SUBJECT: Engineering Review Comment  
Mountain View Electric Association Inc. (The Association)

**Project Name: Retreat at TimberRidge Filing No. 2 – Final Plat**

**Project Number: SF2121**

619 N. Cascade Avenue, Suite 200
Colorado Springs, Colorado 80903

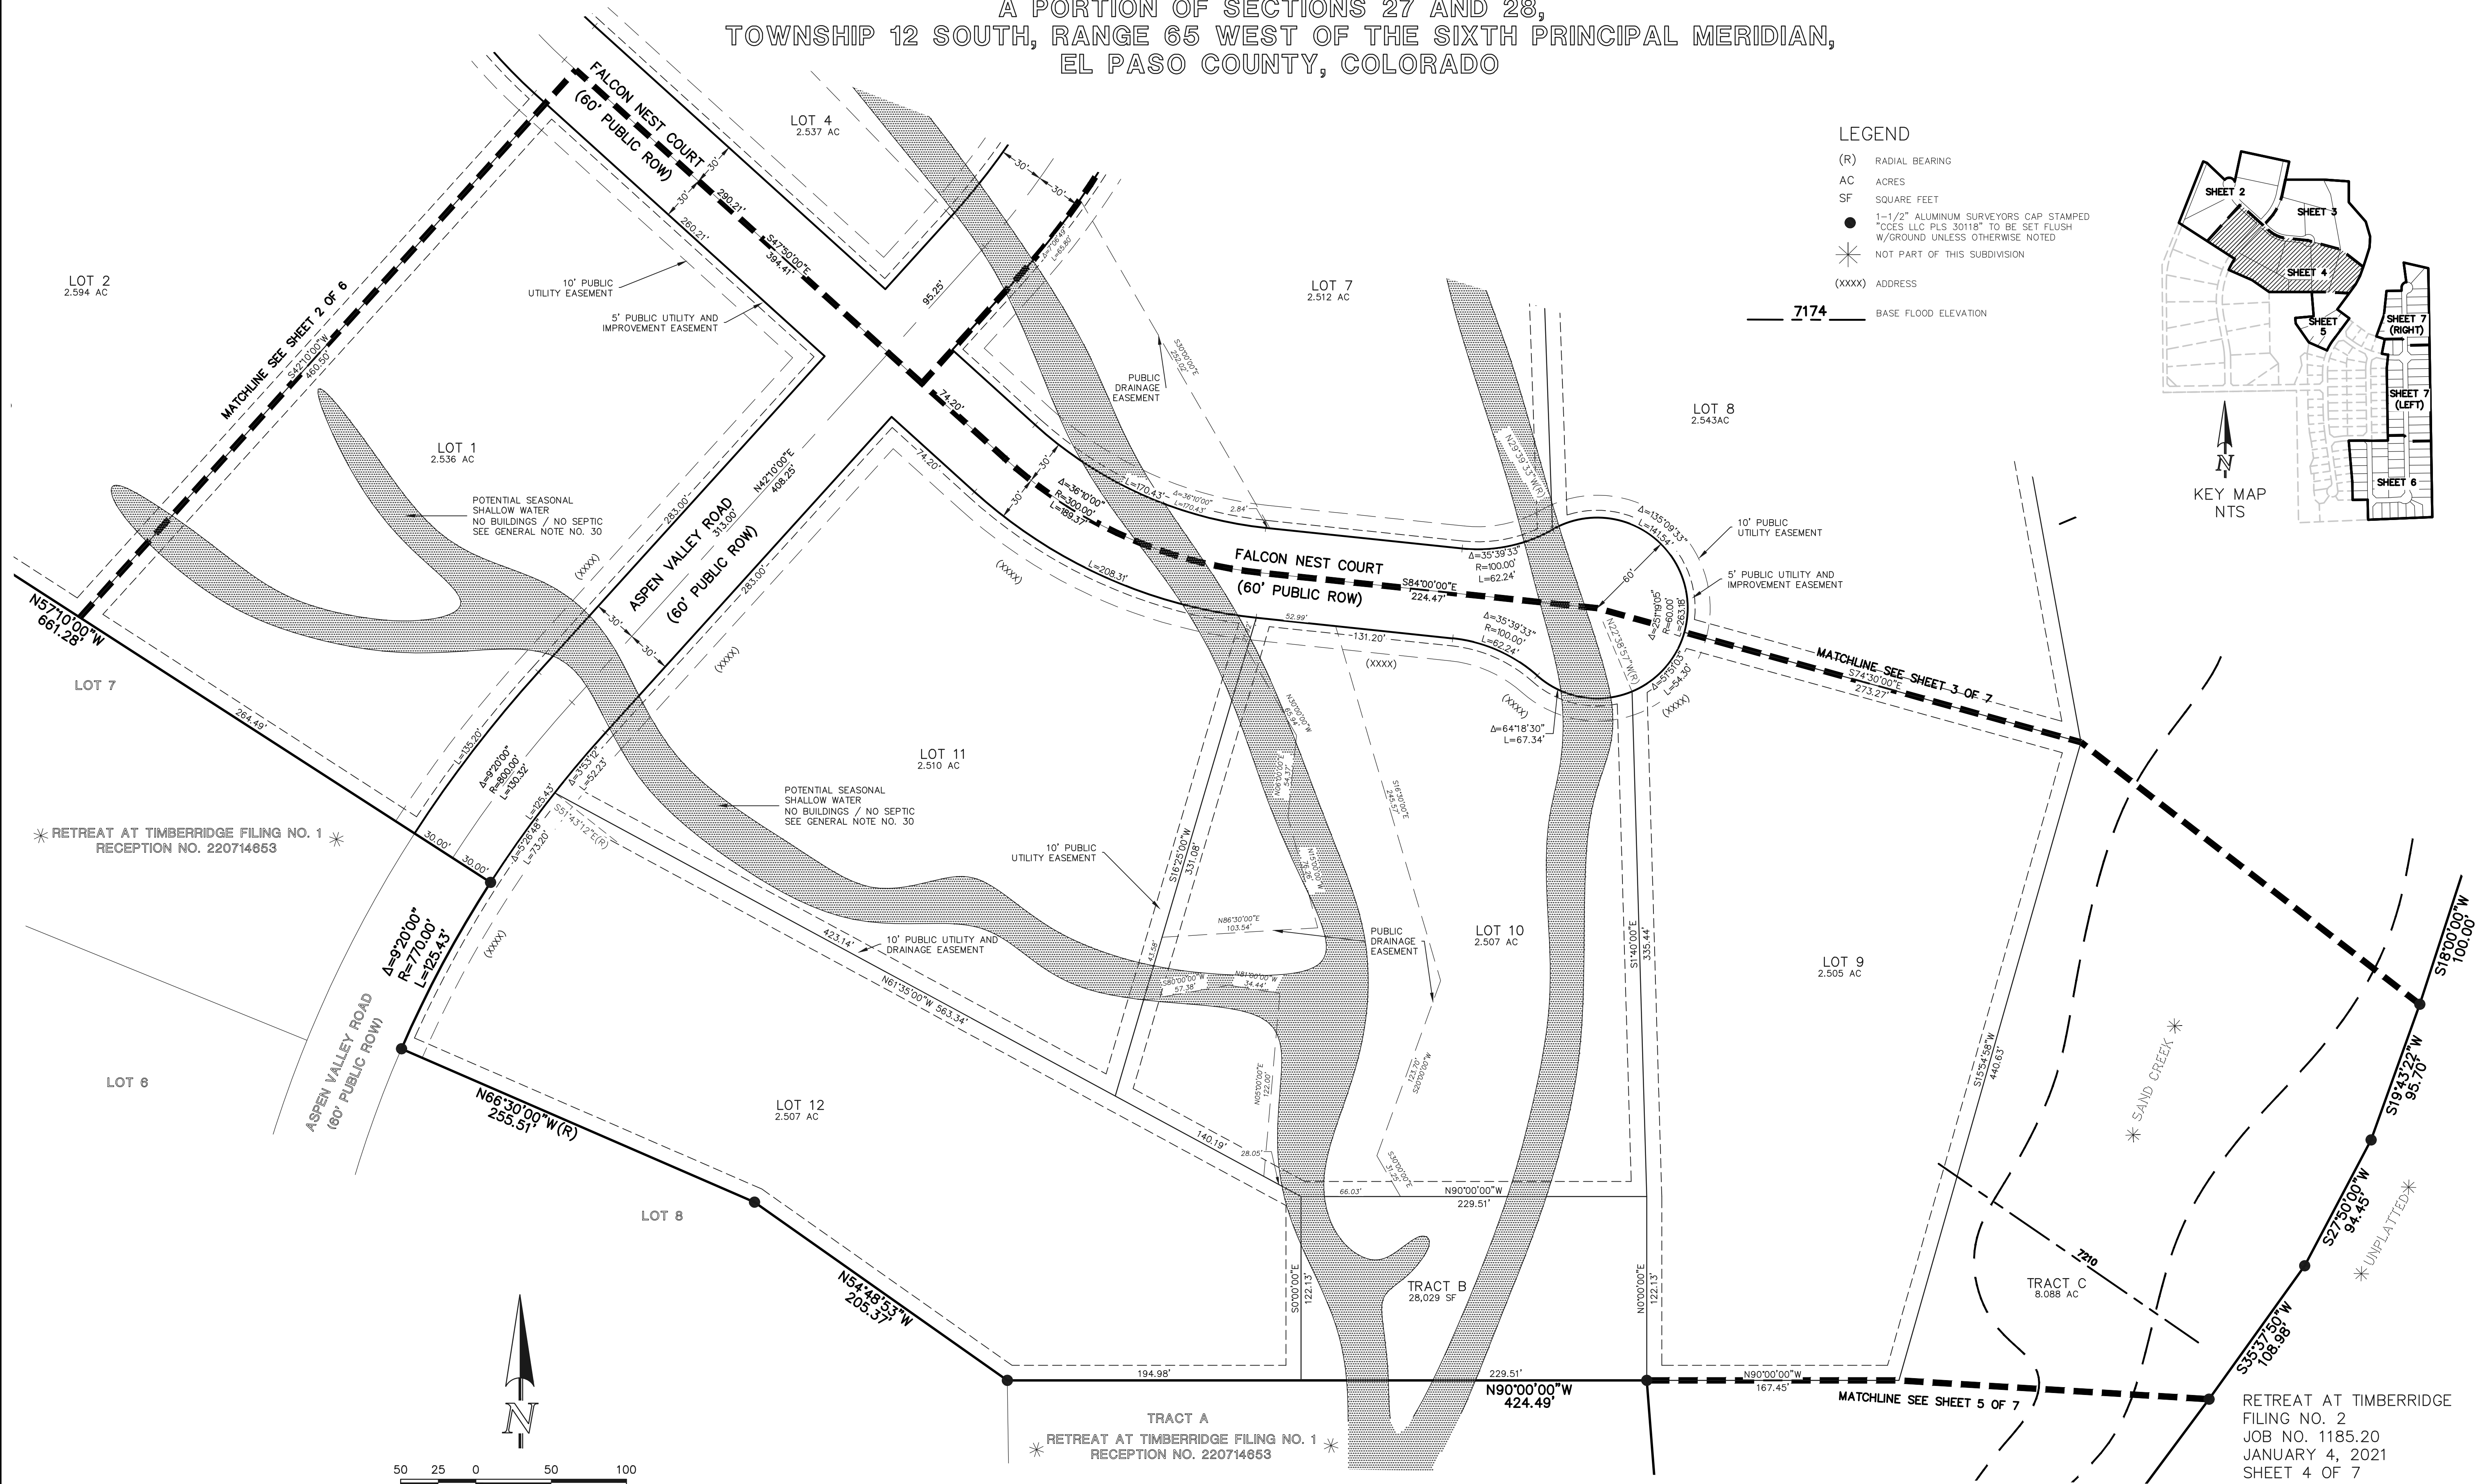
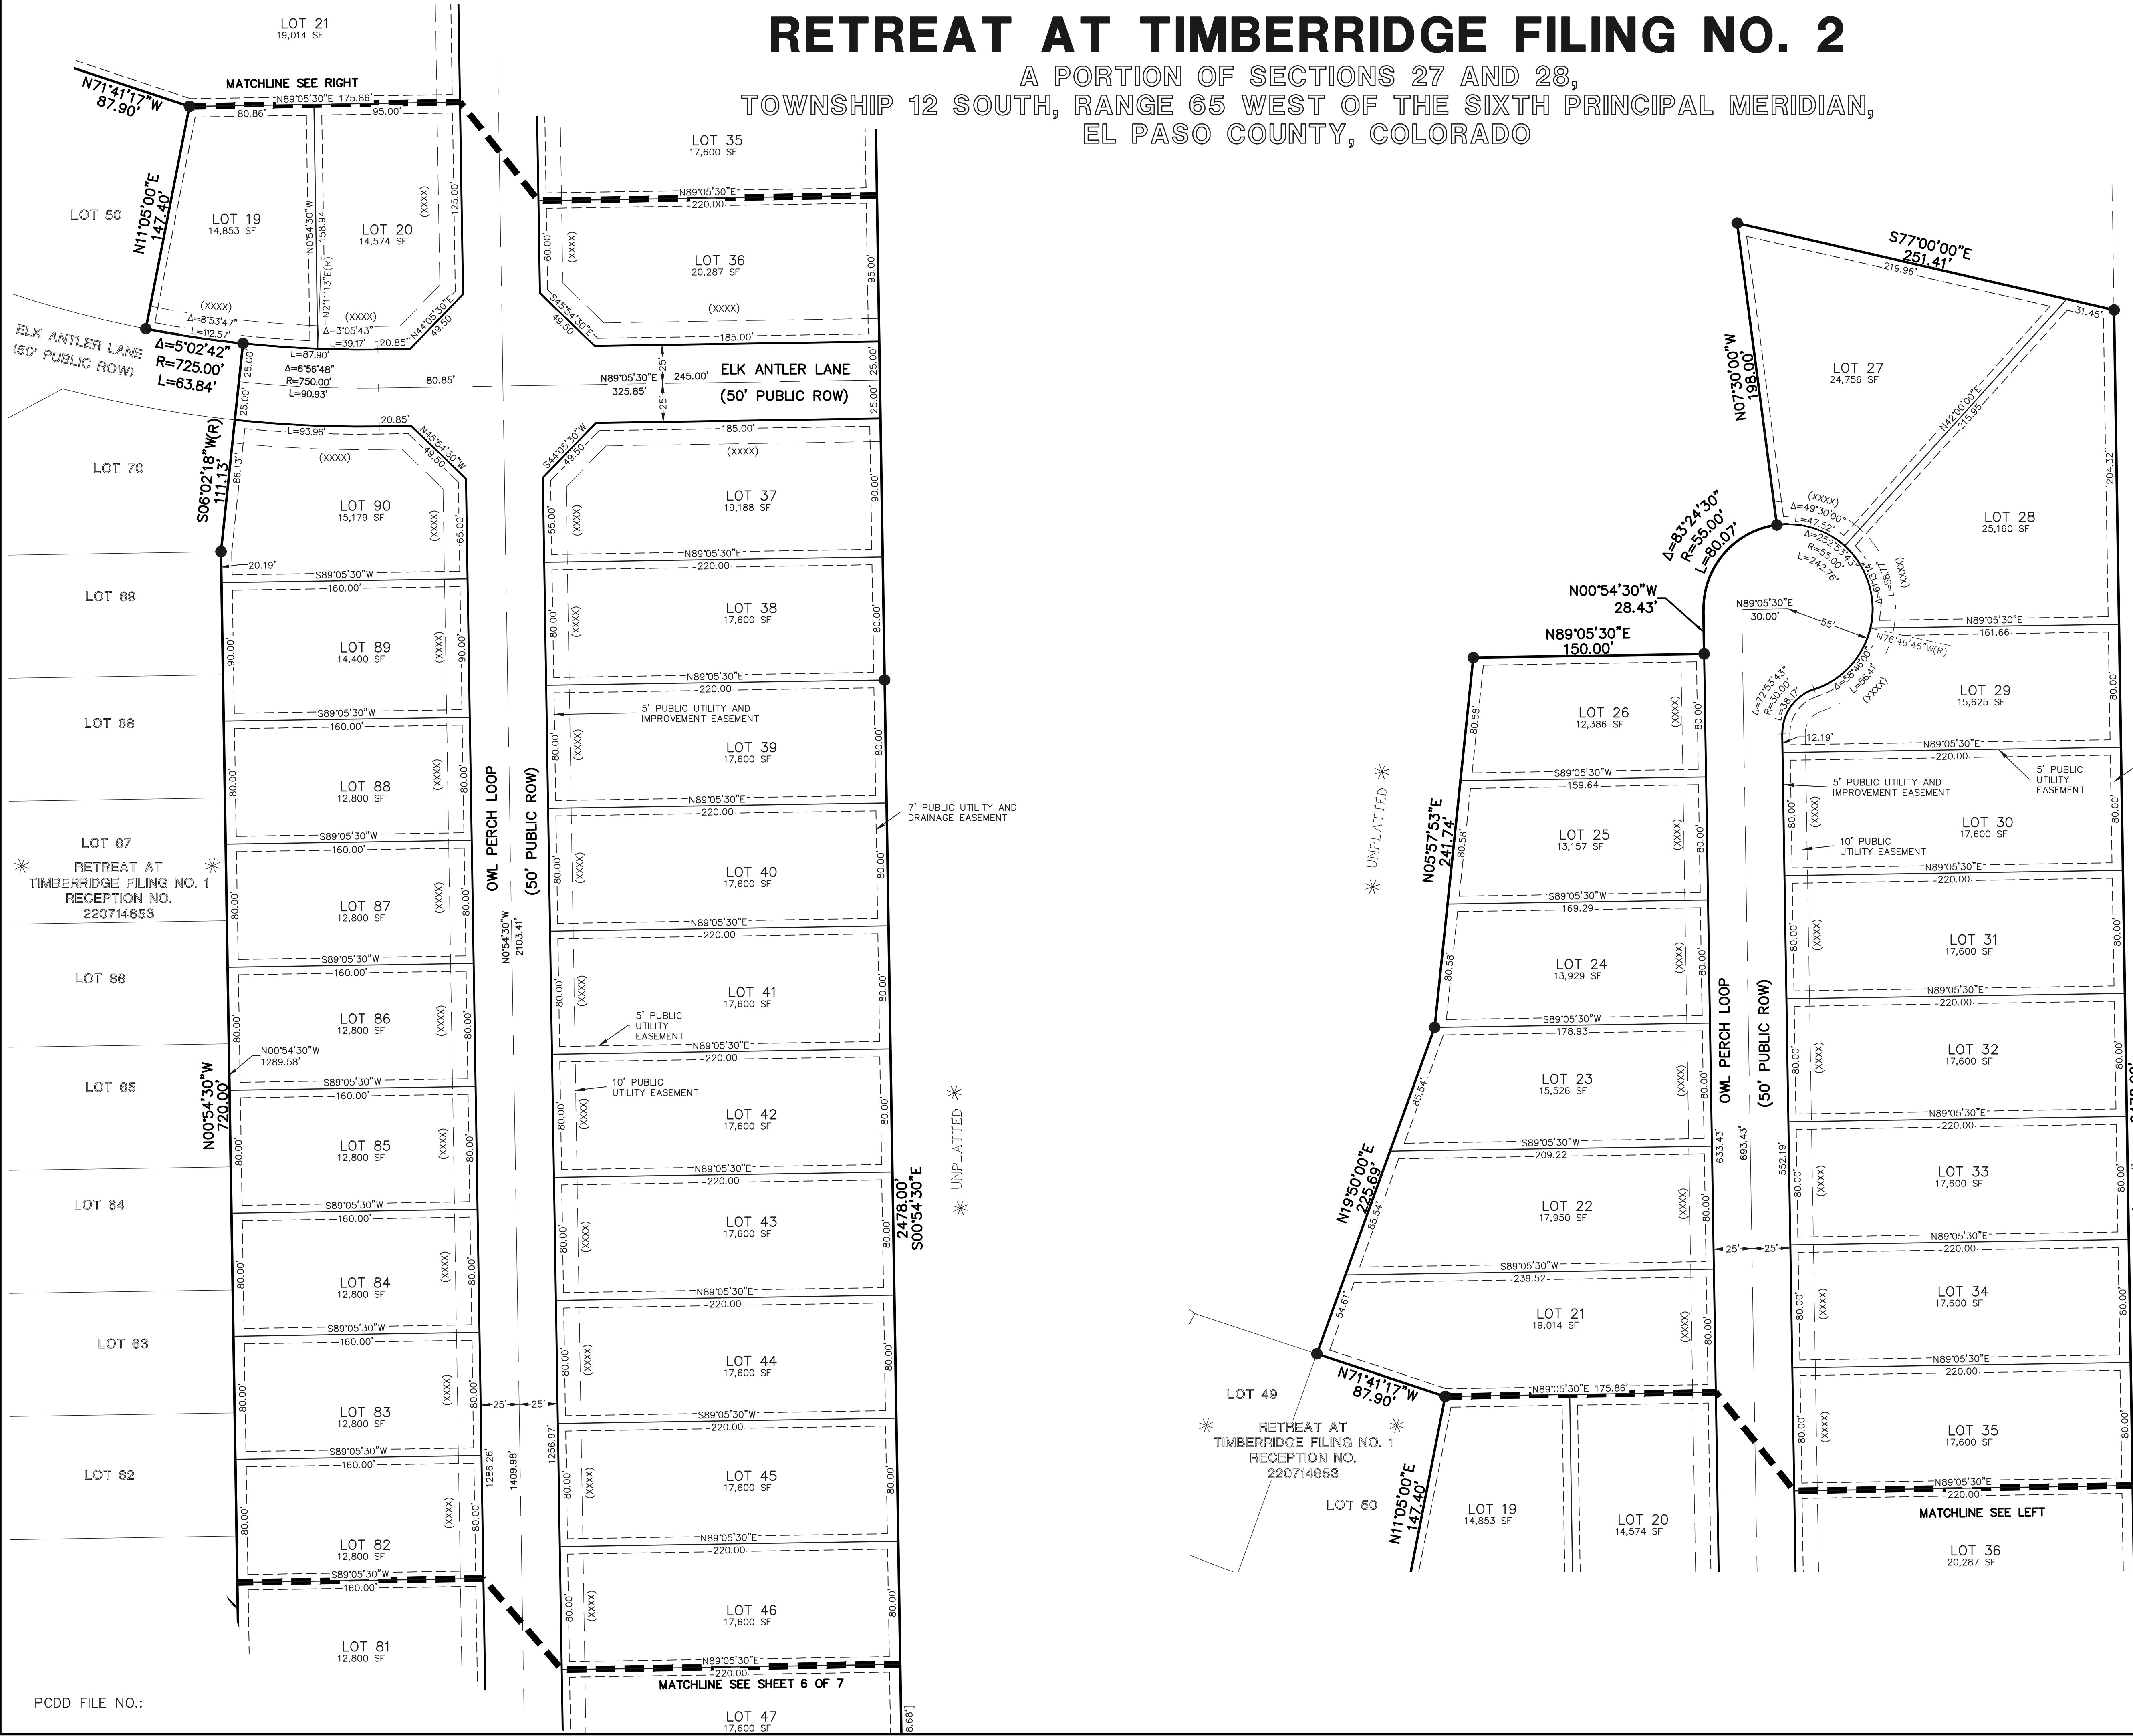
The Association requests a ten (10) foot front lot utility easement, a five (5) foot side lot utility easement, and a seven (7) foot rear lot utility easement along with a twenty (20) foot exterior utility easement on the plat and all tracts include easements. The Association also requests the platting of the Association's existing facilities with easements on the plat. Additional easements may be required.
